## Environmental Health Consultation Response

| <b>Planning Ref</b>        | P/145/25/PL                                                                                                                          |
| <b>Site Description</b>    | 194 - 196 Pagham Road<br>Pagham<br>Bognor Regis<br>West Sussex<br>PO21 3QB                                                           |

I have reviewed the submitted application along with the acoustic report by KR Acoustics ref: KR07461 Issue: v1.2 Dated 5th July 2025.

Site Plan (Imagery © Google 2024)

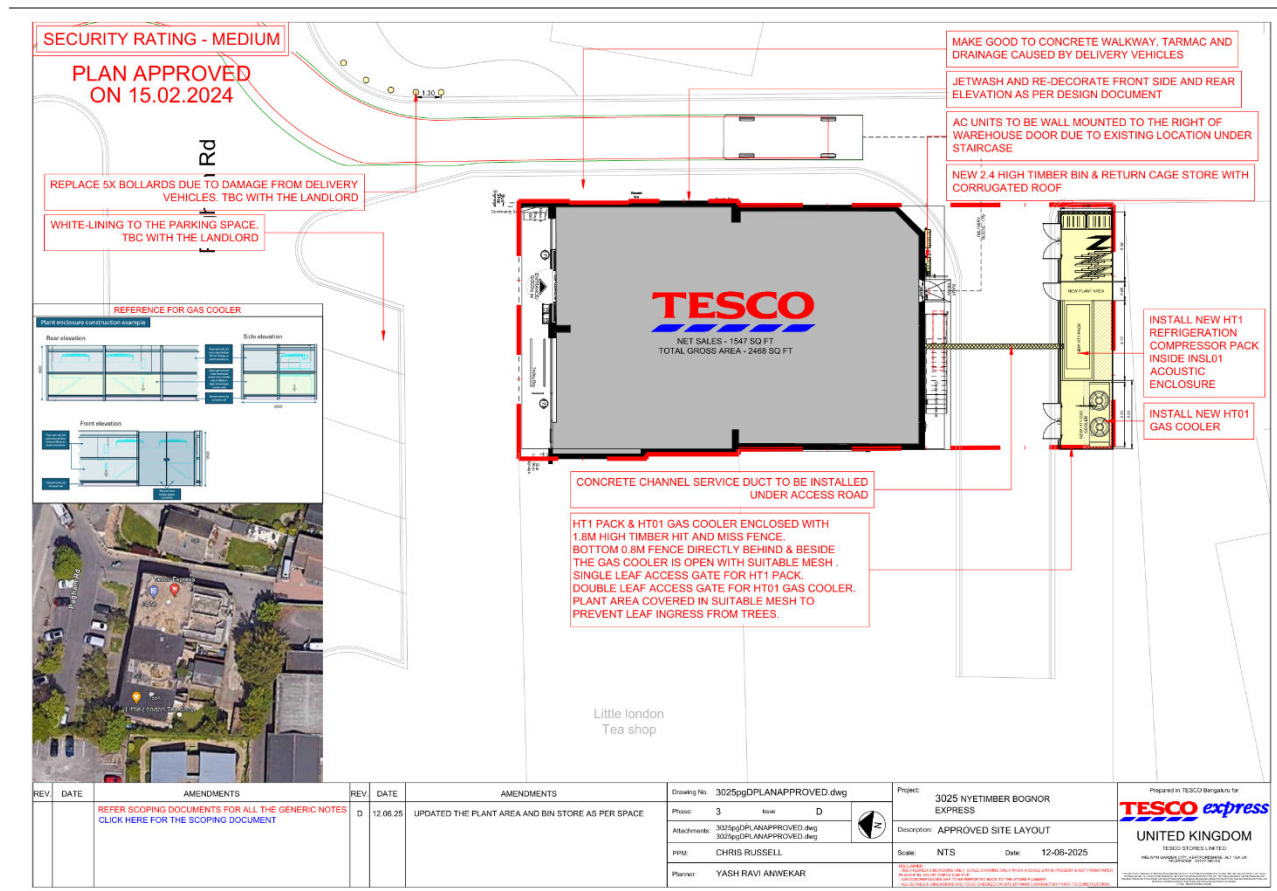
The report has assessed the impact at the bungalow at 198A Pagham Road but there is no discussion about the impact on 198 this is a concern as this property has a 1<sup>st</sup> floor window that appears to have line of site to the plant area, has this been considered?

2.4. Acoustic Enclosure around the Compressor Pack

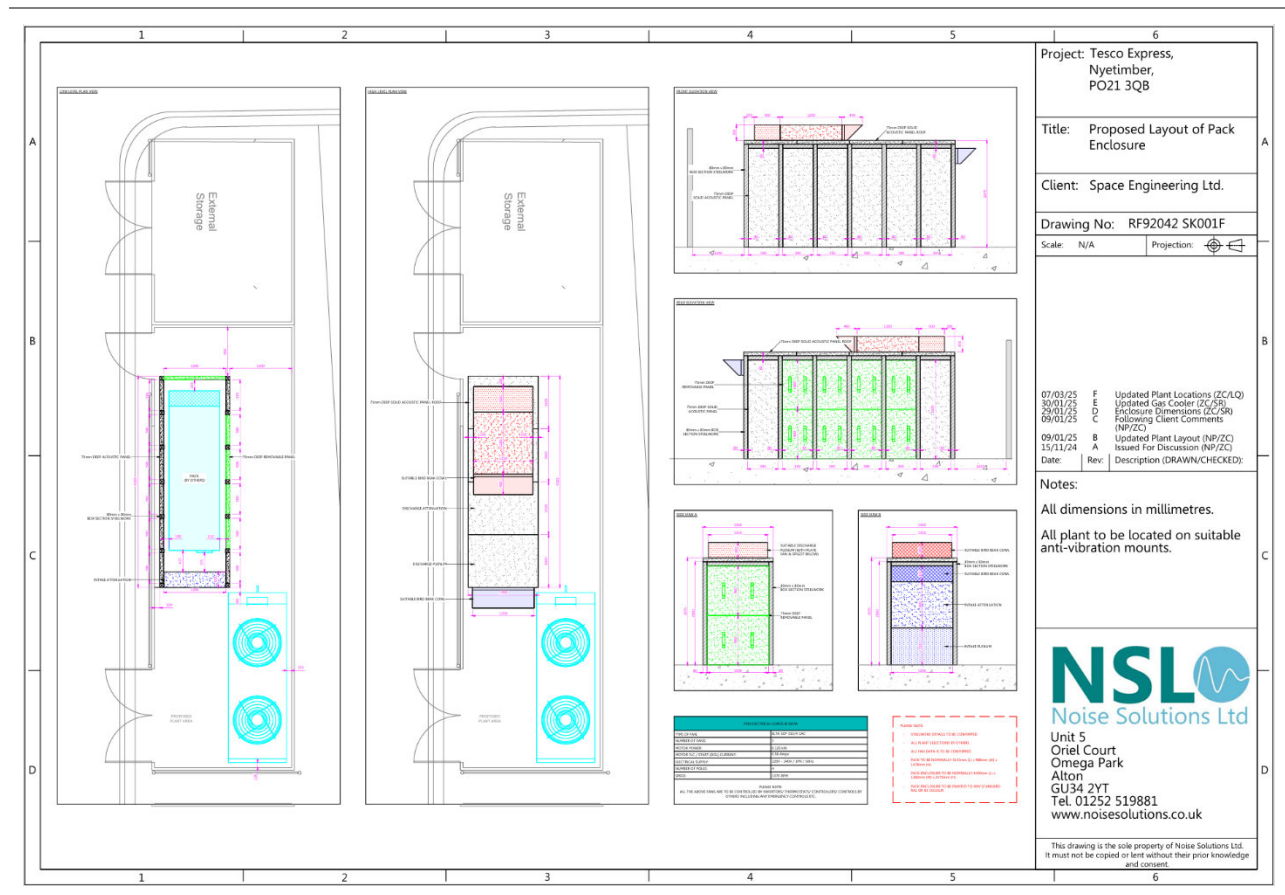
2.5 Shows that the Daikin Heat pumps are shown in “night mode” with no clarification of what this actually means. Is this a permanent setting or does this change? are different times of the day/year when this is not in night mode? and if so what impact does this have on the noise output?
